Subject: Formal Objection to Proposed Ballinlee Wind Farm – Co. Limerick

Reference: An Coimisiún Pleanála Case Ref. PAX91.323780

Figure 4. Projected flight lines from VP surveys illustrating SW-NE trend and the proposed enhancement area. KDE isopleth bands are used as a swan-day index for levels of site use with opacity increasing with intensity of use (1-25%, 25-50%, 50-75%, > 75%) as in Figure 3.

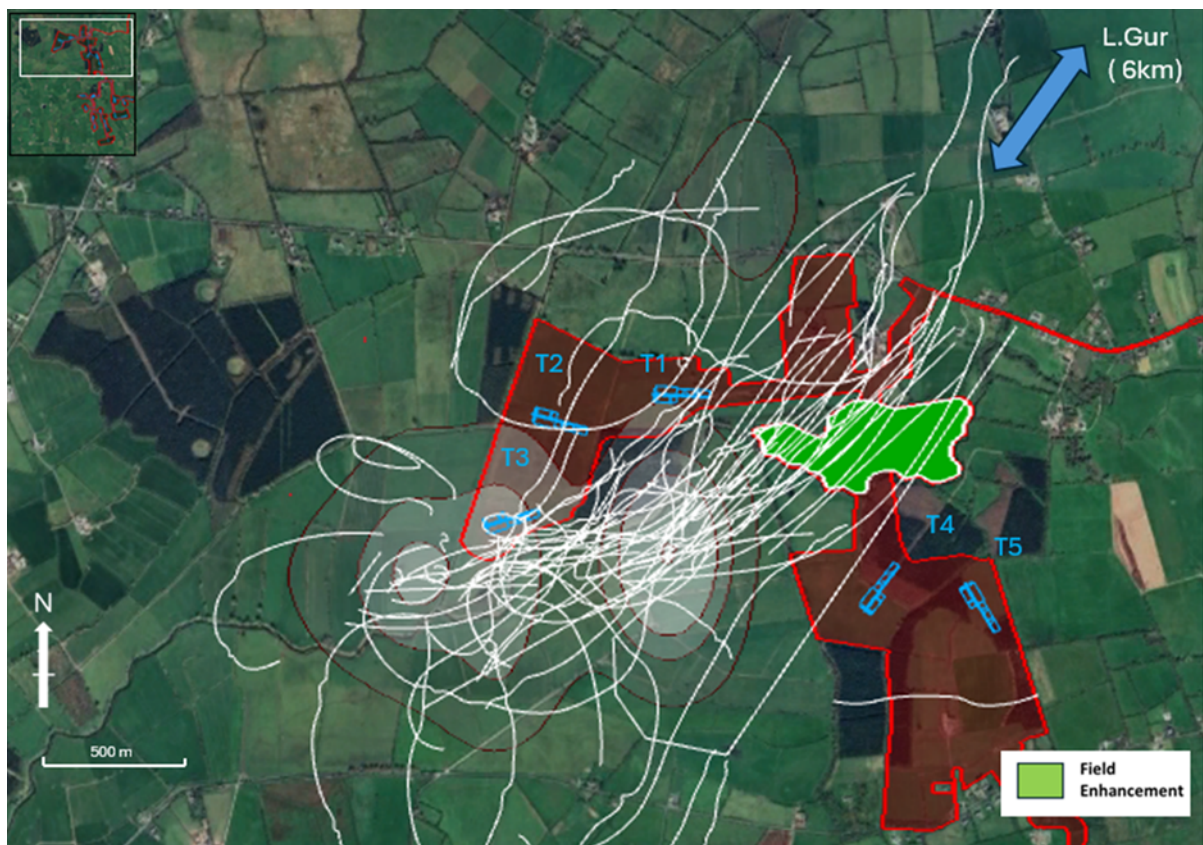
Turbines T1–T5 lie directly in the protected flight paths of Whooper Swans (*Cygnus cygnus*). The Whooper Swan Management Plan (Appendix 7D) not only identifies critical migration, roosting, and feeding areas near the site but also clearly shows flight paths that pass directly through T1 to T5, as illustrated in the photo below. The presence of turbines in these critical flight paths creates serious risks of collision, displacement, and increased energy expenditure, which could negatively affect the survival and breeding of these protected birds. Even with turbine shutdowns during peak movements, residual risks remain, especially in poor visibility or adverse weather conditions. Proceeding with this development would undermine obligations under the EU Birds Directive and could have long-term ecological consequences for this internationally protected species.
